Recommendation Report for Planning Permission for Works or Extension to a Dwelling

REF NO: M/56/17/HH

LOCATION: 8 Beaconsfield Close
Middleton-On-Sea

PROPOSAL: Demolition of existing flat roof garage & construction of replacement single storey pitch roof side & rear extensions

Title
Elevations as Proposed

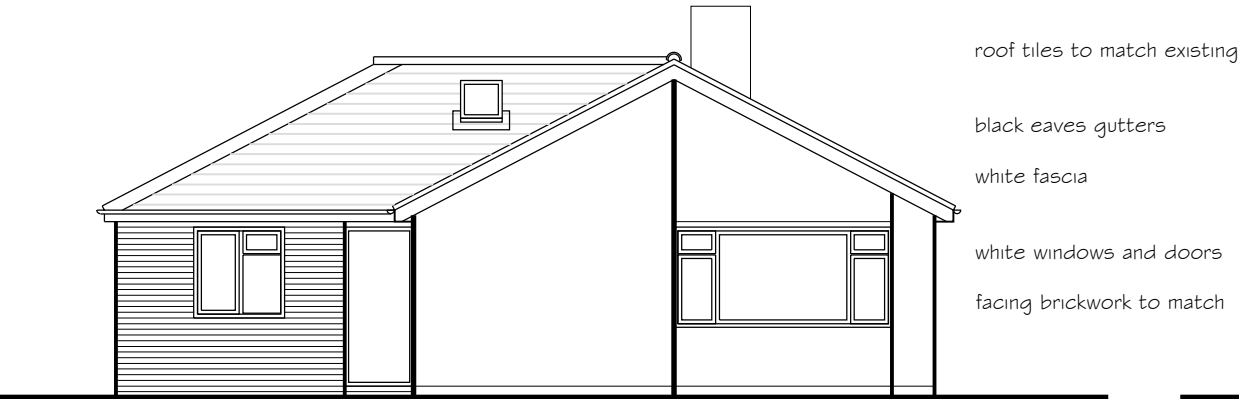
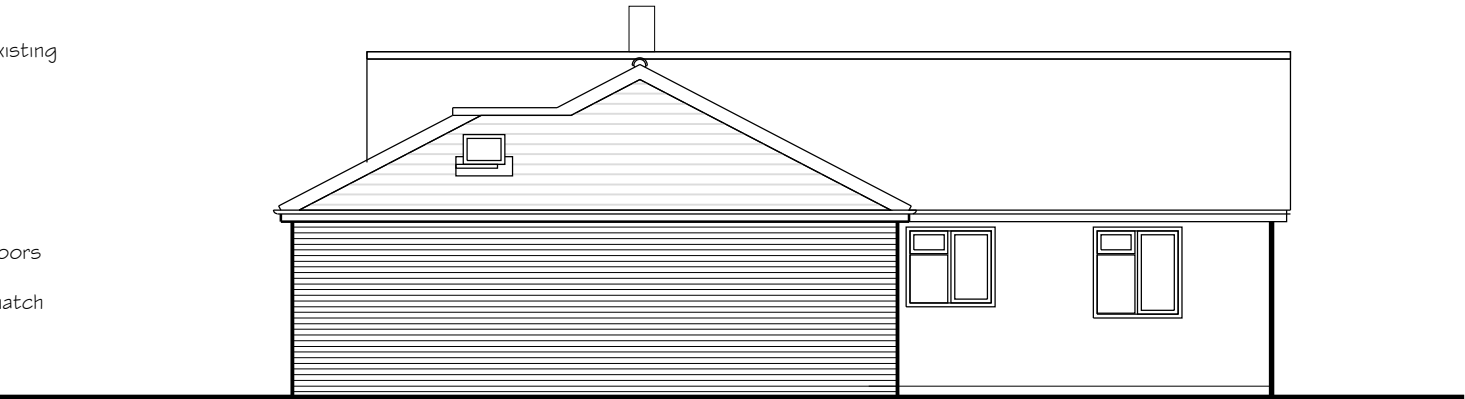
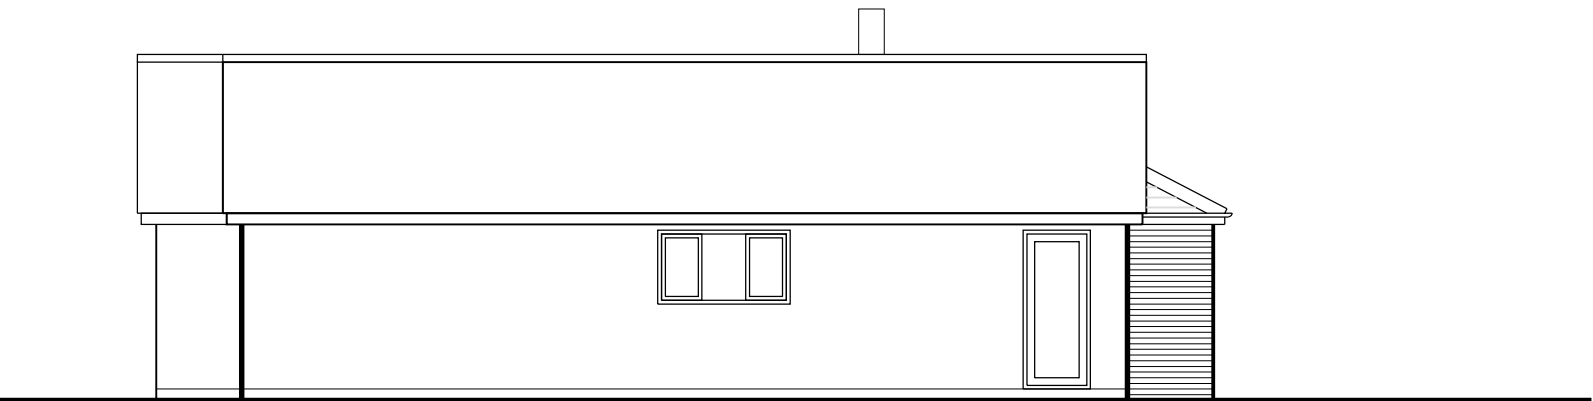
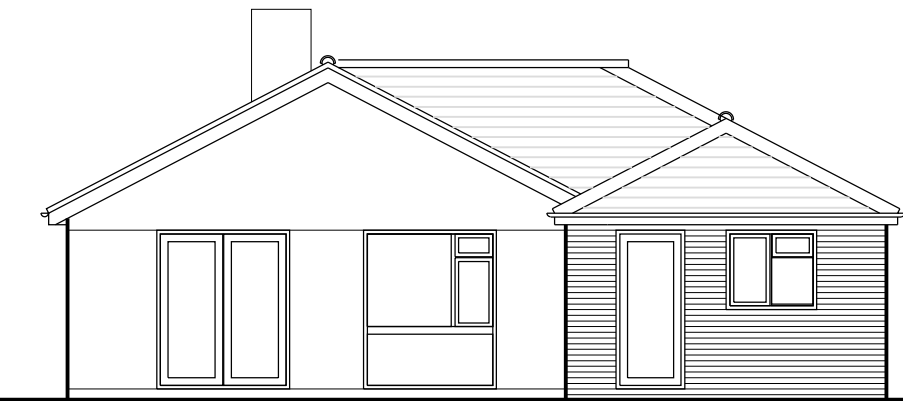
The proposed single storey side extension is sited approximately 5m behind the front elevation of the existing house and 12.5m from the front boundary of the site. The extension would be built up to the boundary with No.10 and replaces the existing single storey flat roof garage. The extension would have a height in line with the existing ridge line of the house when viewed from the front, this is reduced to the rear. The extension would be visible from the street. Materials are to match the existing house.

Comments have been received regarding the size of the extension however, this has now been reduced in depth and it is not considered that the proposed extension is unduly large in principle and as such an unduly dominant addition. The change from the single storey garage to provide a hipped roof extension would alter the appearance of the property. However, given the set back of the extension and the height of the extension as a whole it is not considered that the proposed development as a whole would have any adverse harm to the character and appearance of the host property or the wider area.

With regard to the amenity of adjoining occupiers the proposed extension would be built up to the boundary with the property to the north No.10. There are no side windows in the proposed extension and the rear window is at ground floor level therefore there would not be an unacceptable level of overlooking to No.10. Given the existing garage and the height of the proposed extension, albeit the pitched roof increases the overall height, the eaves height is comparable to the height of the existing garage. Therefore, it is not considered that the proposed, amended, extension would be harmful to the amenity of adjoining occupiers at No.10.
